## **Development Facilitation Team (DHO) – Review Comments**

**DRB Project No: PR-2019-003169 Date: 10/11/2023 Agenda Item:8 Zone Atlas Page: L-10**

**Legal Description: Tract 401 UNIT 3, Atrisco Grant (MX-M)**

### **Application For: SD-2023-00132 – PRELIMINARY PLAT (DHO)**

**SAGE PARK
SKETCH PLAT**

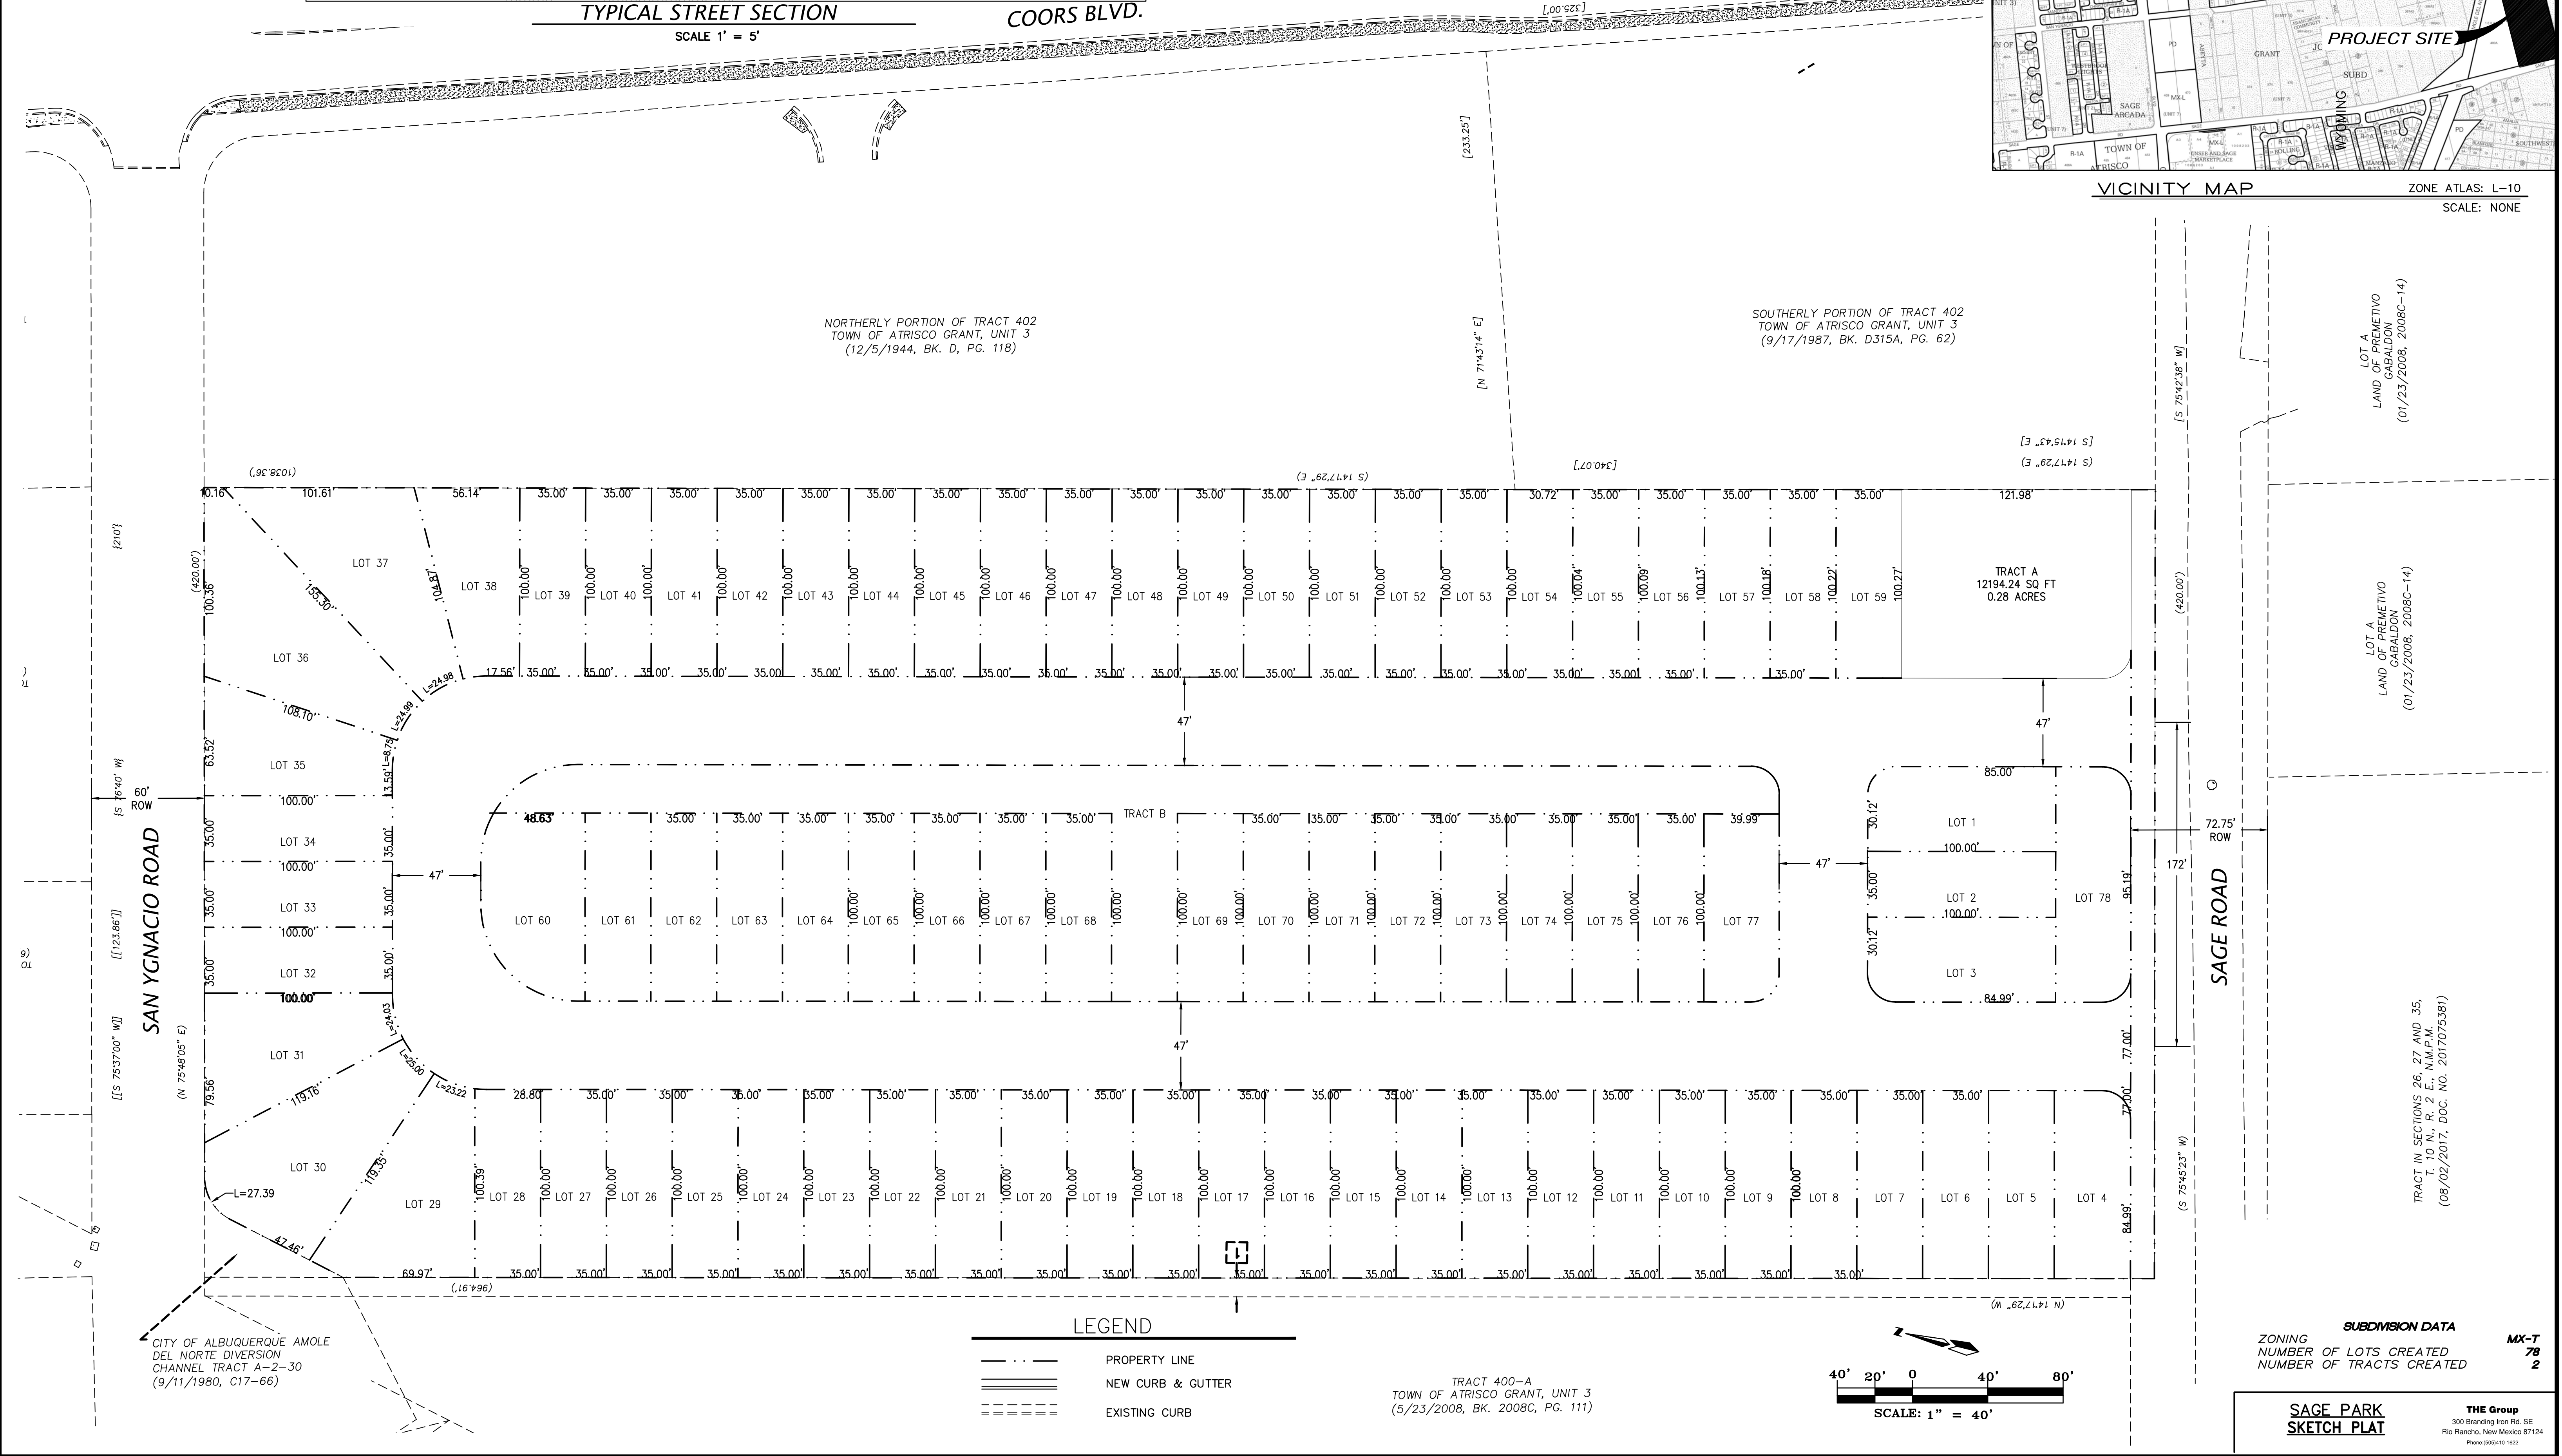
3. The proposed easements within proposed Tract D include landscape and drainage. The Water Authority is not accepting of landscaping within a public easement for water and/or sanitary sewer infrastructure. Please remove the landscaping easement and clarify what type of drainage easement this will be for. There shall be no concrete run down or rip rap above the waterline.

- a. Discussion: Is the drainage easement for utilization for a main corridor for drainage? What is the purpose of that easement? Will there be a pedestrian access across this corridor? If so, the preferred surface will be asphalt and we want to ensure no erosion will occur above the WL.

4. Infrastructure List:
  - a. Please look at the waterline within Tract D. The line should extend to San Ygnacio from Parsley Rd. proposed line. It currently states Tract D from Parsley to Sage St. which does not give clear indication of a location of a line within Tract D. Please state that it will connect to existing line in San Ygnacio as well.

- The applicant has shown a willingness to adjust the pedestrian/bicycle connection to the Amole Diversion Channel. This is to help overcome long block lengths. The following diagram was sent to the applicant and it is requested that this minor change be made to the plat.
